GOVERNMENT ARCHITECT NEW SOUTH WALES

PROJECT: 2-4 Giffnock Ave Macquarie Park

RE: State Design Review Panel – 15th October 2025 – Review 3

Landscape Detail Plan
Yura Place

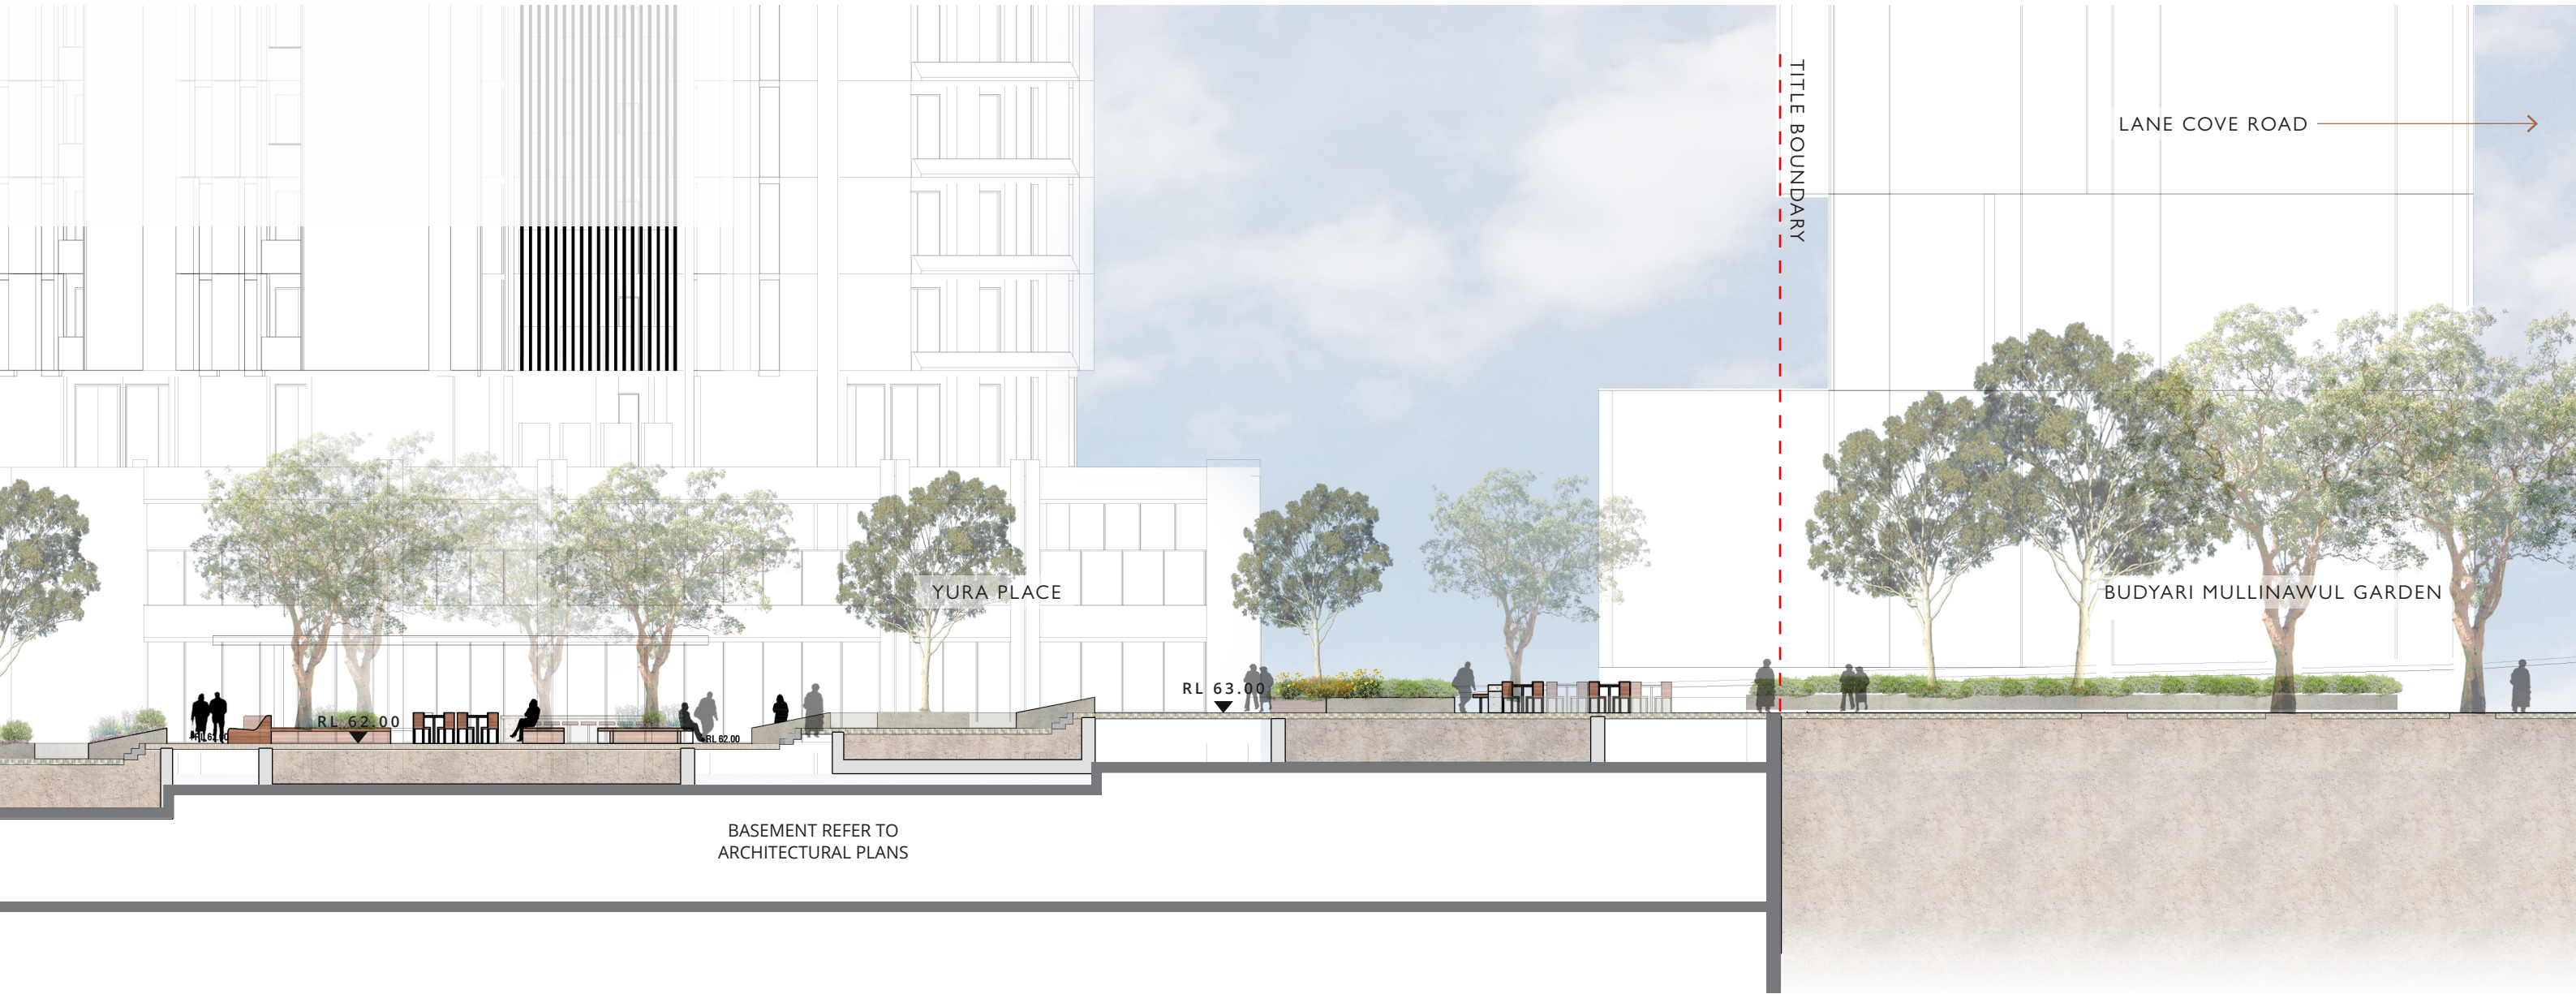
- Refine the configuration within Yura Place to improve legibility and create diverse activity zones. Explore how these changes can reduce clutter and increase soft landscaping opportunities.

- 4. Demonstrate that the minimum 20% canopy cover required under the MPDG has been achieved for the developable site (per Advice Letter 02, Item 10).
- 5. Optimise canopy cover by exploring the following opportunities:
 - a. revise the configuration of the ramps within Yura Place to better accommodate a range of canopy trees
 - b. provide an additional avenue of trees along the 'Community Green Link' to future-proof for any potential road widening and resultant tree loss
 - c. increase the spread of the on-structure Yura Place soil to provide for a continuous soil network that can accommodate larger, resilient, trees.

Children's Outdoor Play (L01) Landscape Typologies

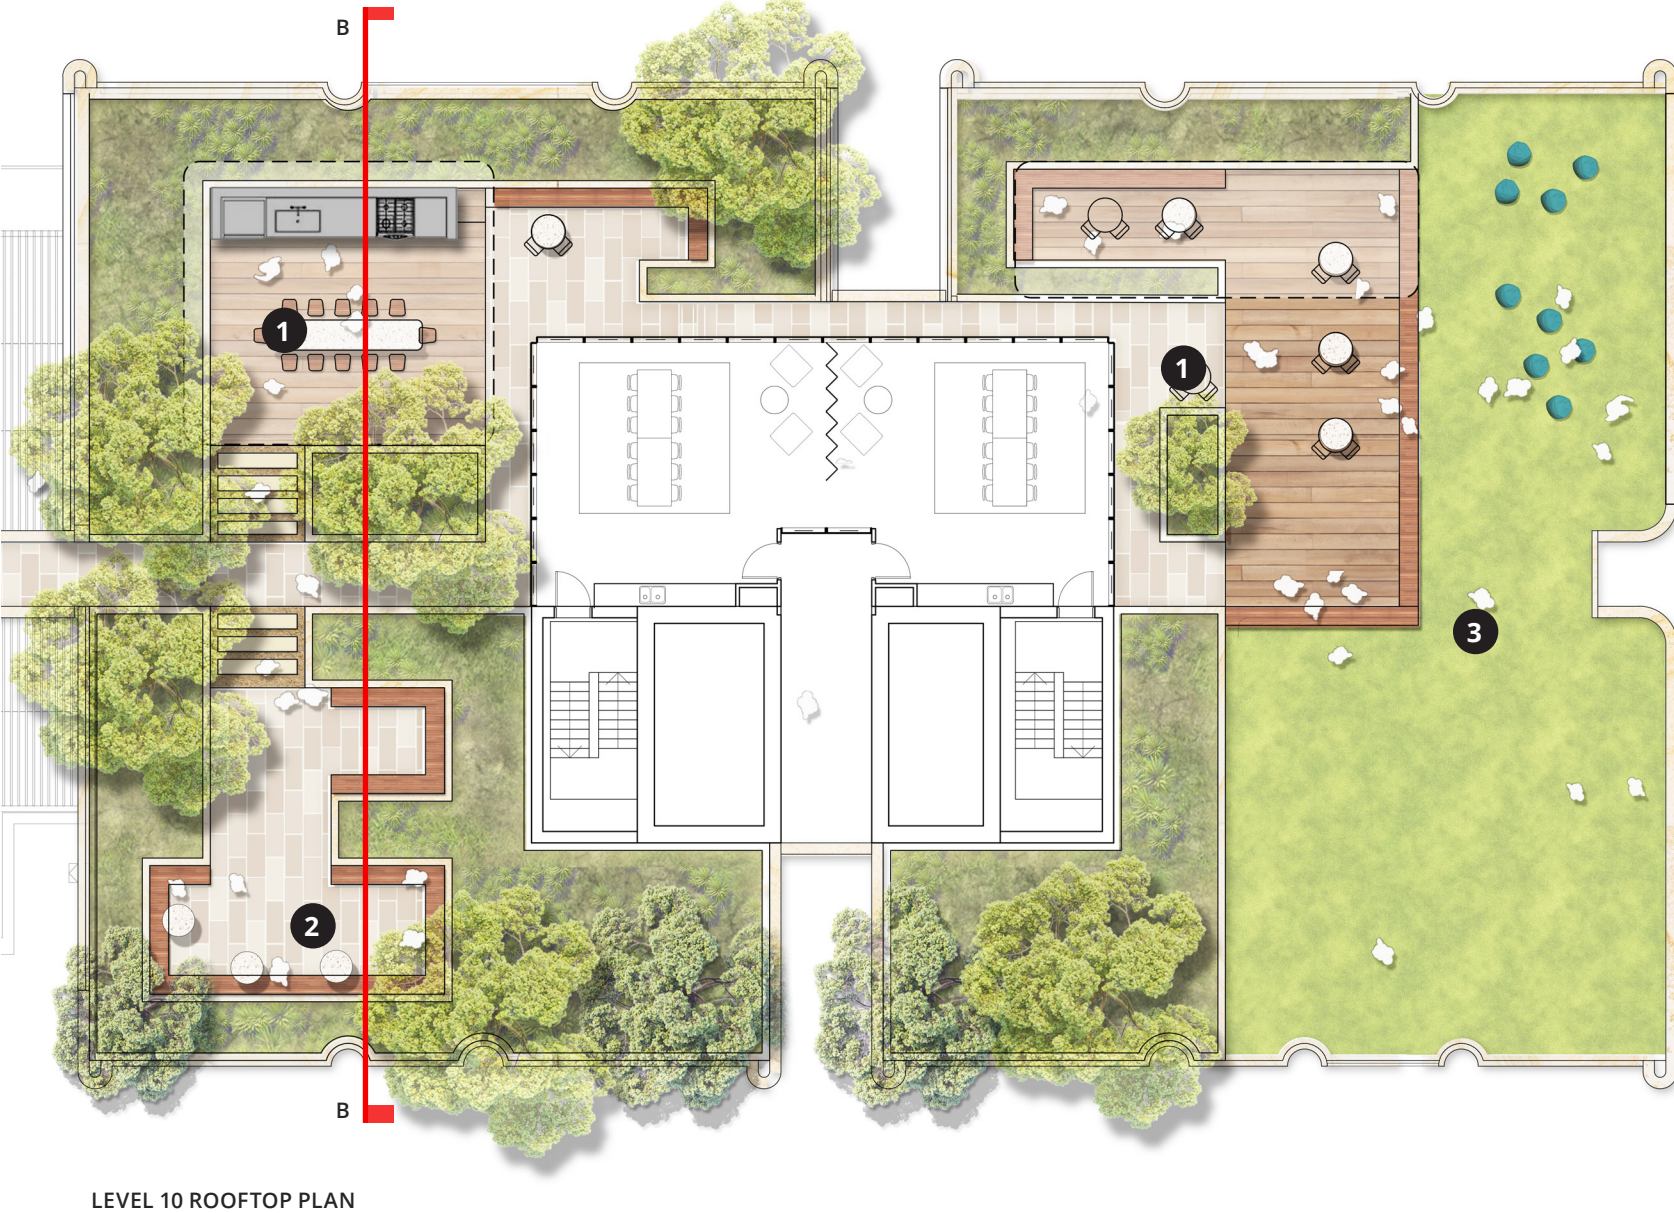
- Increase floor to floor heights to 3.2m in line with the servicing requirements for the NCC.
- Introduce additional openings within the eastern façade of the eastern outdoor play space of the childcare centre to ensure natural cross ventilation will be provided.

Masterplan Analysis

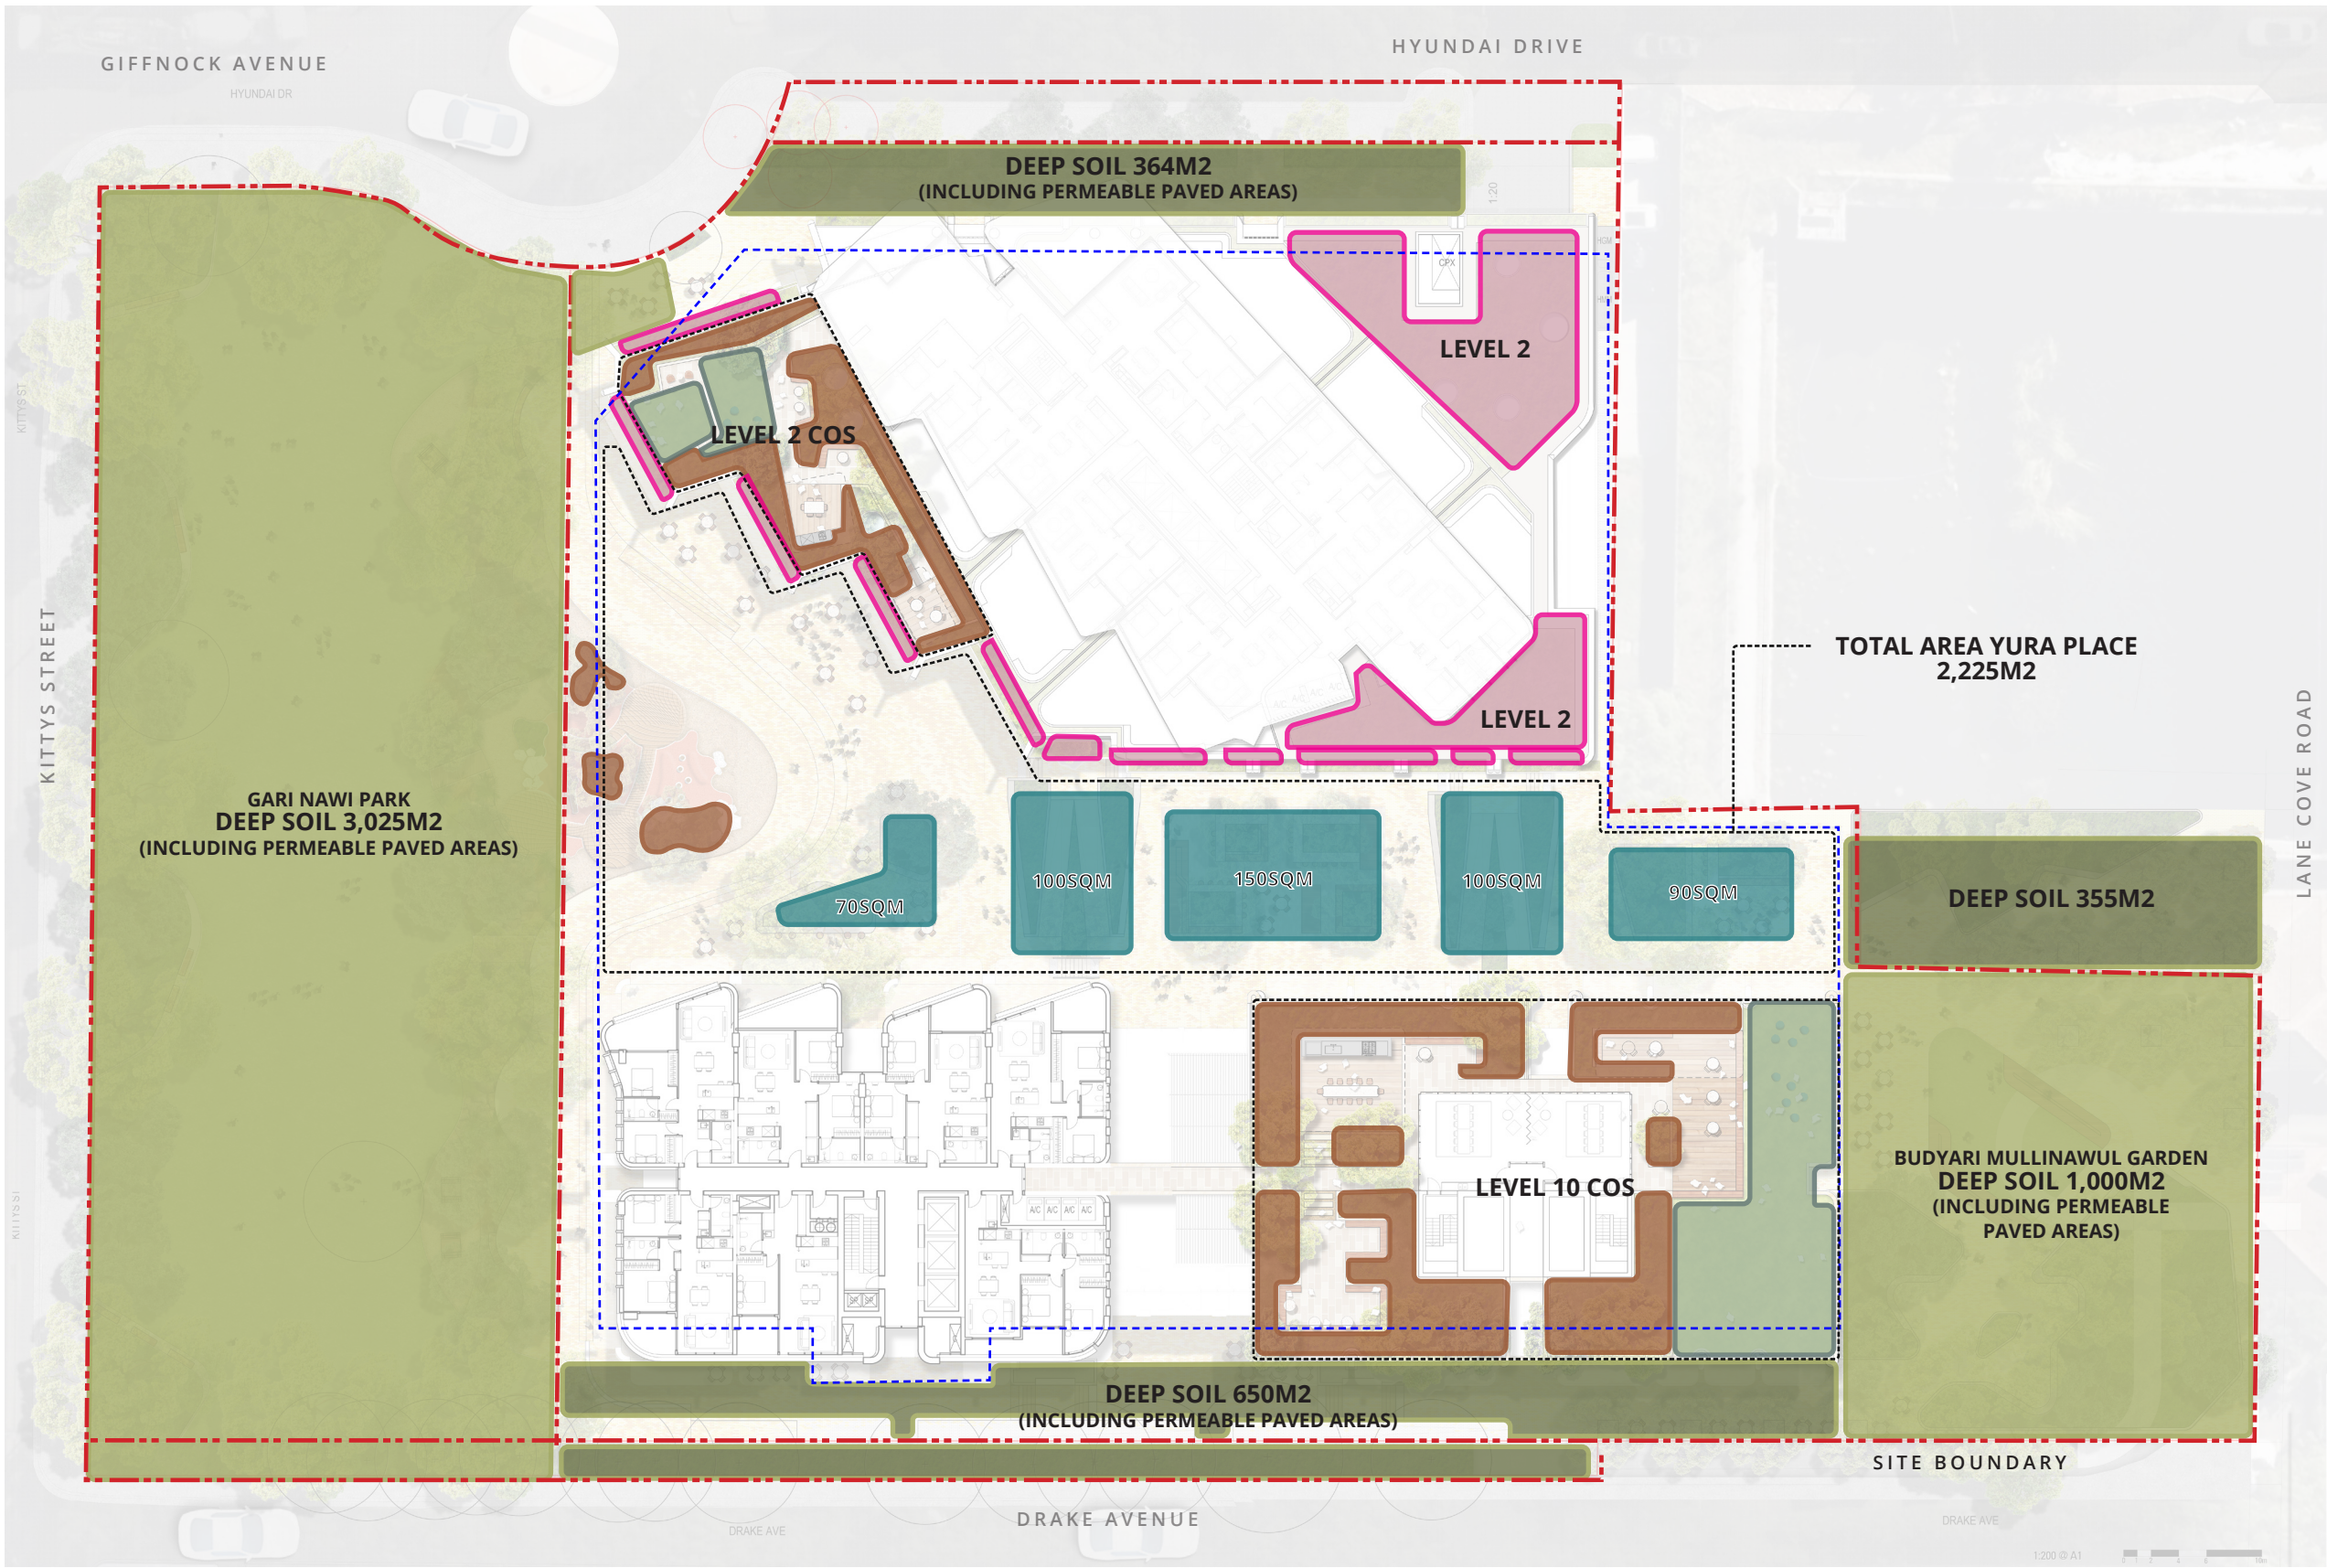
- Increase deep soil within the developable site. The quantum and quality of deep soil is below the 15% minimum and includes calculation of areas of hardstand as deep soil.

The two identified deep soil areas of 'Community Green Link' and 'Giffnock Arrival' are predominantly hardstand and do not constitute genuine deep soil. Additionally, the total area of 14.73% deep soil (1,153 sqm) is still below the 15% minimum required under the MPDG, and unchanged from the amount presented at SDRP 02 (refer Advice Letter 02, Item 9 on attaining a minimum of 15% deep soil).

3. Increase the provision of genuine deep soil to 15% of the developable site (per Advice Letter 02, Item 9). Measure areas without hardstand and that are a minimum 3m by 3m dimension per the MPDG. Explore the following opportunities:
 - a. optimise all hardstand areas to create genuine, connected deep soil areas
 - b. explore provision of additional deep soil areas:
 - along the interface with Veriu Serviced Apartments
 - through minimising required hardstand needed for loading dock access
 - by reducing the basement extent
